# Rezoning Transportation Analysis

Petition Number: 2023-172

## Revision Log:

Date	Description
01-23-24	First Review (IW)
02-21-24	Second Review (KC)
03-26-24	Third Review (DR)
05-09-24	Trip Generation Update 1
05-23-24	Trip Generation Update 2
05-29-24	Fourth Review (IW)

**C1.0**

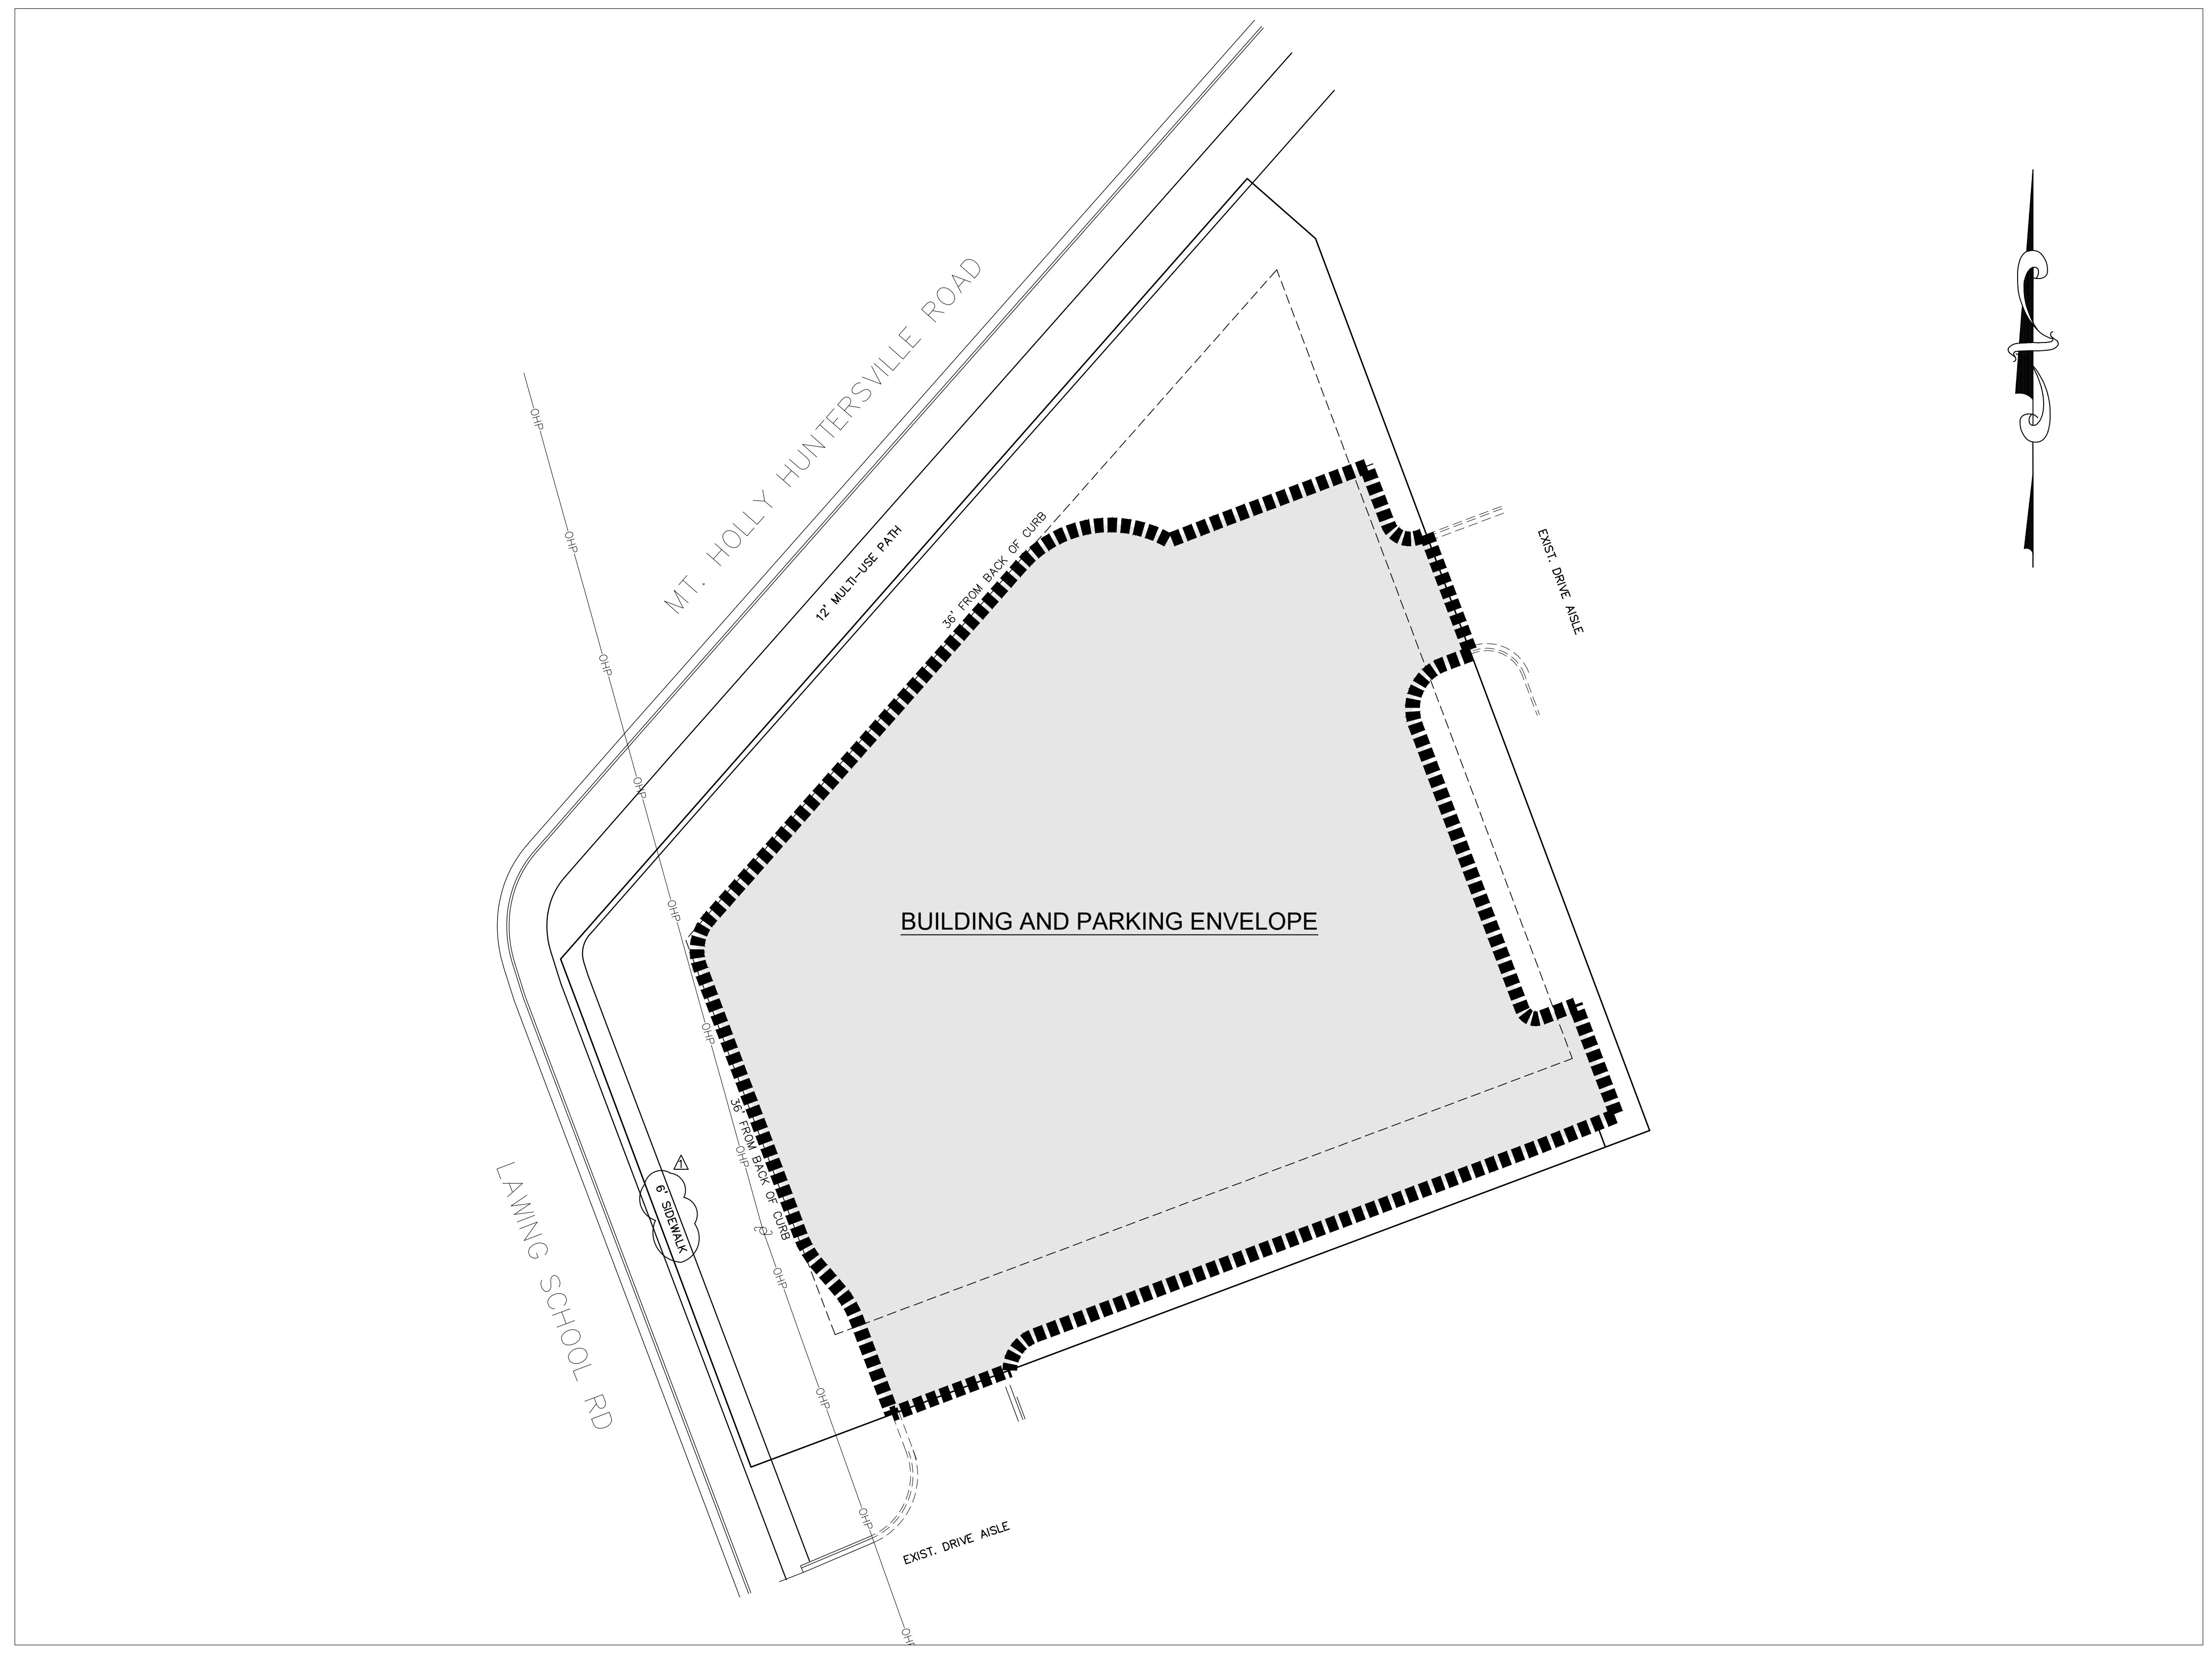
7. ~~Revise site plan and conditional note 5.c. to specify which sidewalk the site is committing to constructing. The site plan shows a 12' MUP but the note references the Local Collector Street, which is actually CLDSM U-07B not a local narrow street. The sidewalk would be required to be 8'. Please update and specify which sidewalk width the site plan will be committing to.~~

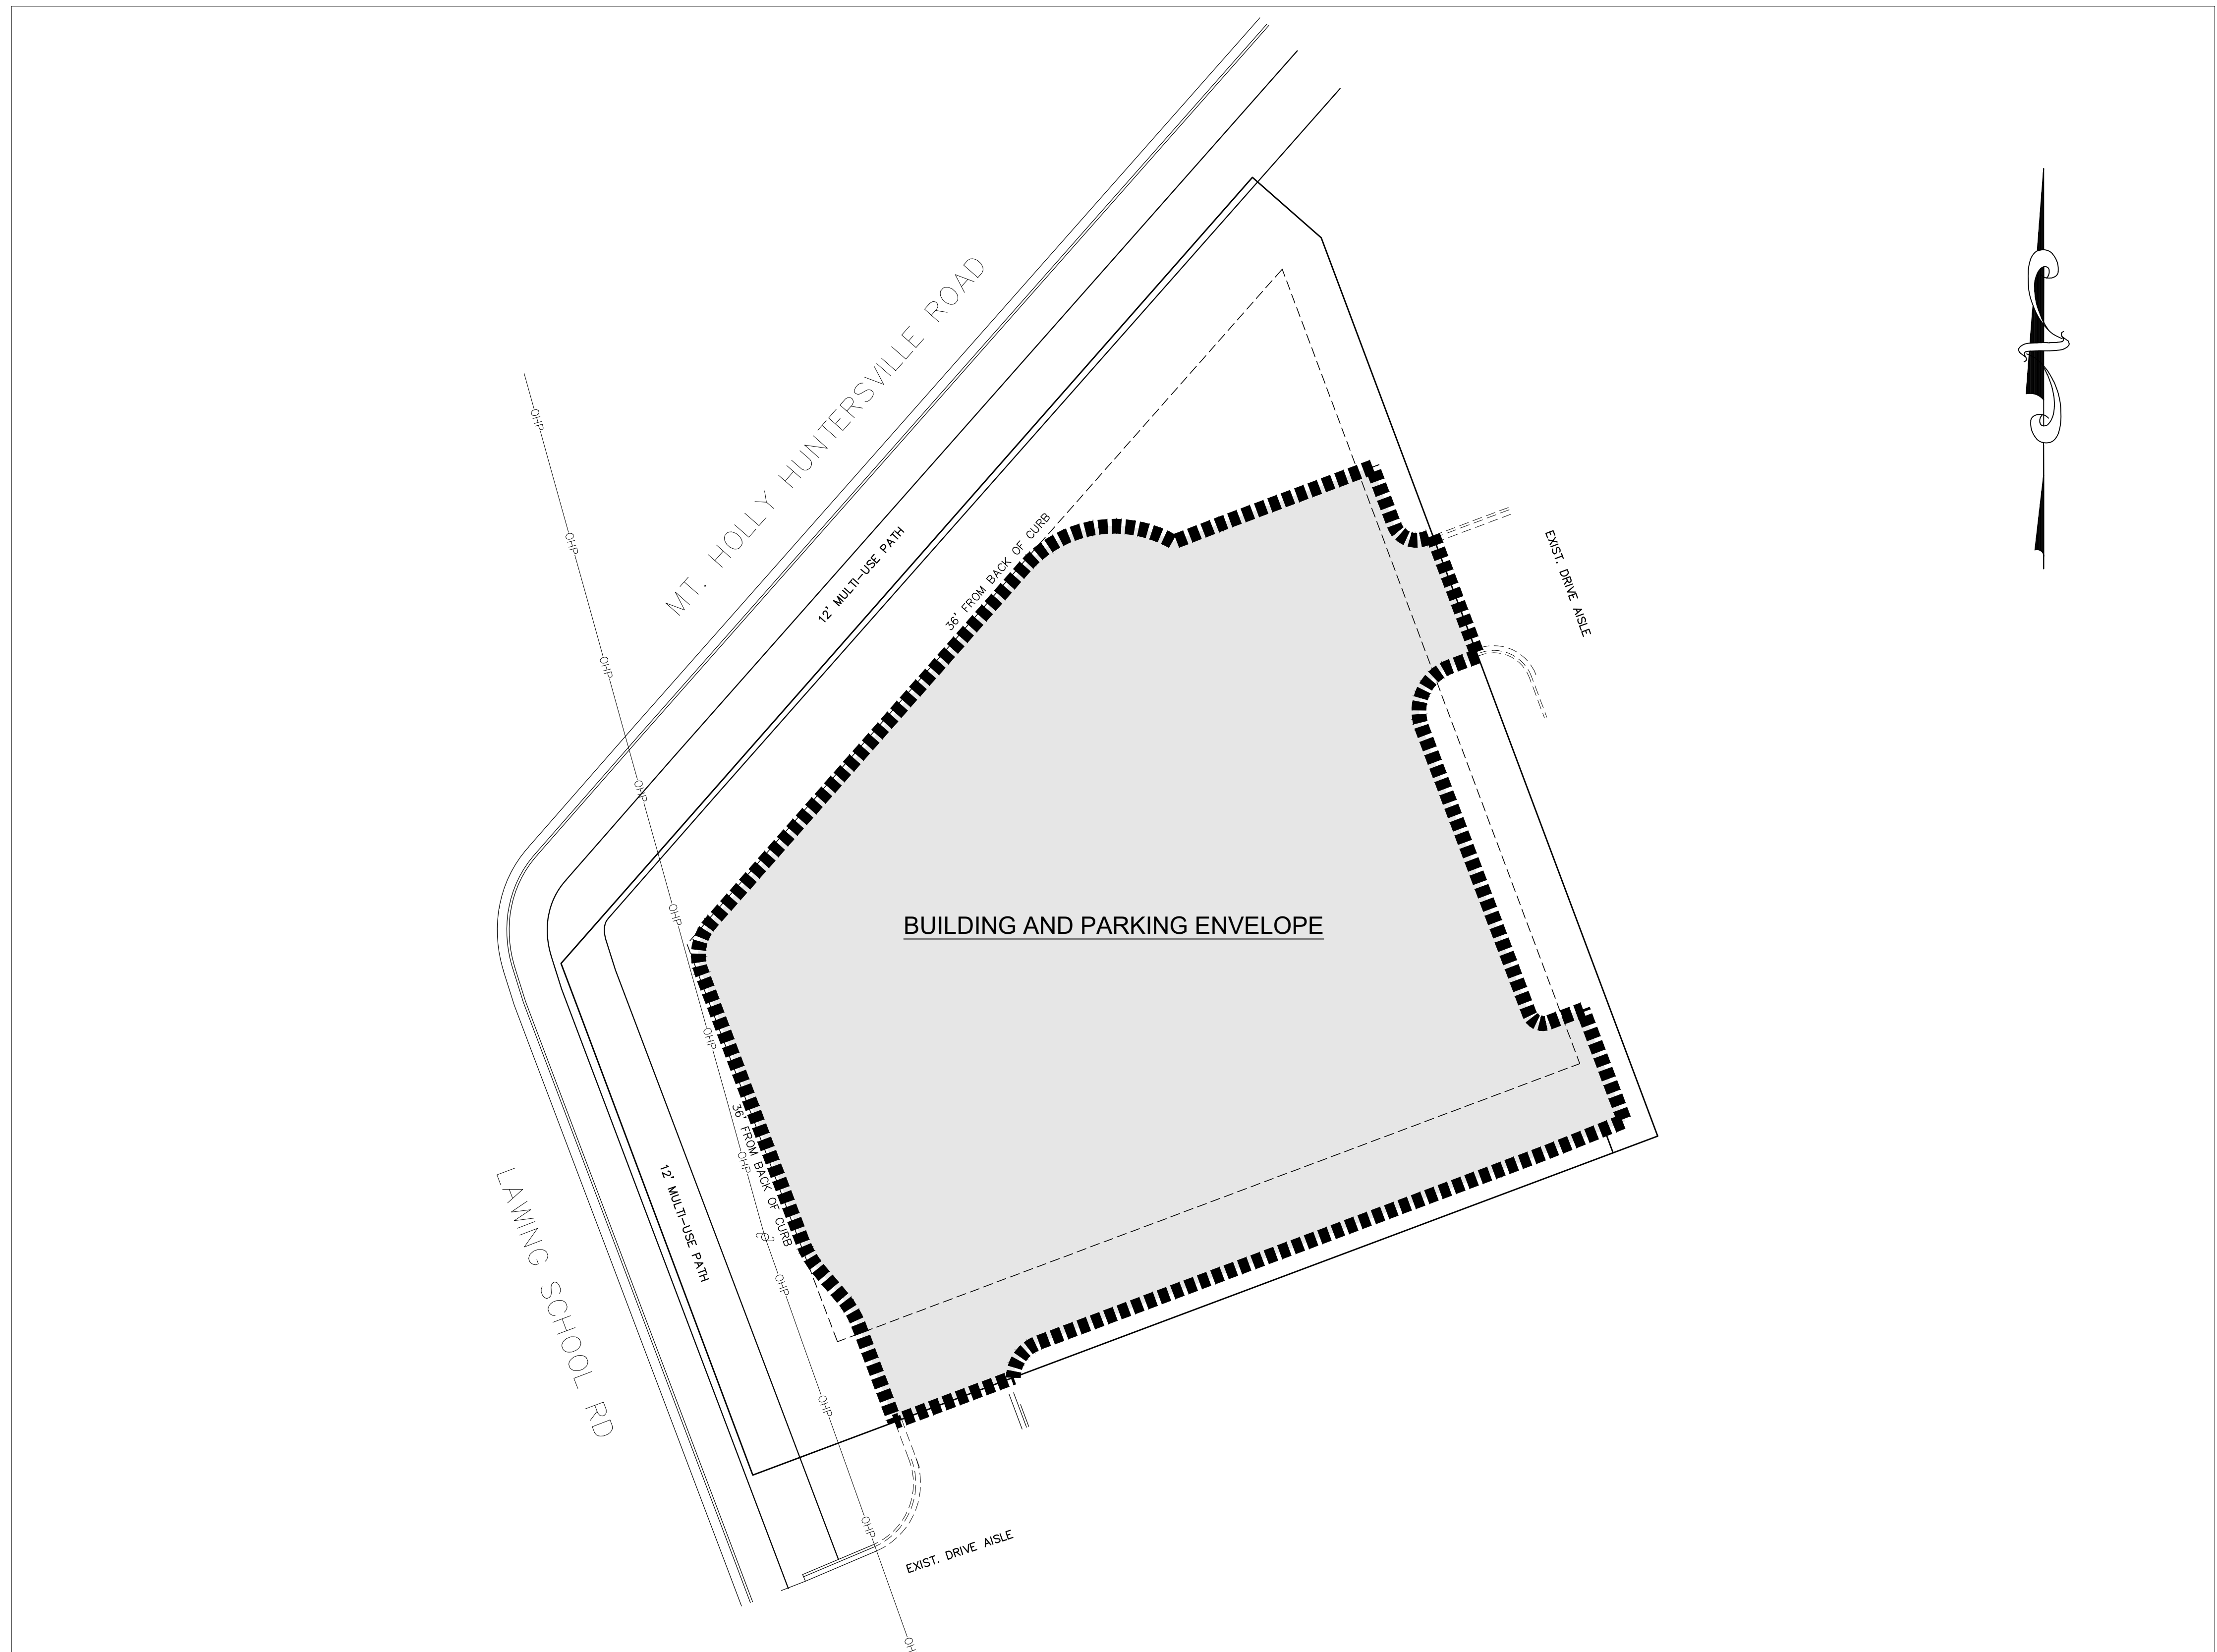
- a. ~~**Mt Holly Huntersville Road:** The future location of curb and gutter is 30' from centerline and appears to be in its existing location.~~

- b. ~~**Lawing School Road (Spell it out):** The future location of curb and gutter is in its existing location.~~

~~Label and dimension the curb and gutter from the centerline for each road on the site plan.~~

3. ~~Revise site plan and conditional note(s) to commit to dedicate 50 feet of right-of-way from the Mt. Holly Huntersville road centerline. The site plan shall label and dimension the right of way from the road centerline.~~

4. ~~Revise site plan and conditional note(s) to commit to dedicate 33.5 feet of right-of-way from the Lawing School road centerline. The site plan shall label and dimension the right of way from the road centerline.~~

6. ~~Revise site plan and conditional note(s) to commit to cross access at south eastern portion of site along Lawing School Road to align with Article 31 in the UDO. It appears the site may be committing by layout on site plan. CDOT would like to see labeling and/or language stating this will specifically be set up for cross access.~~
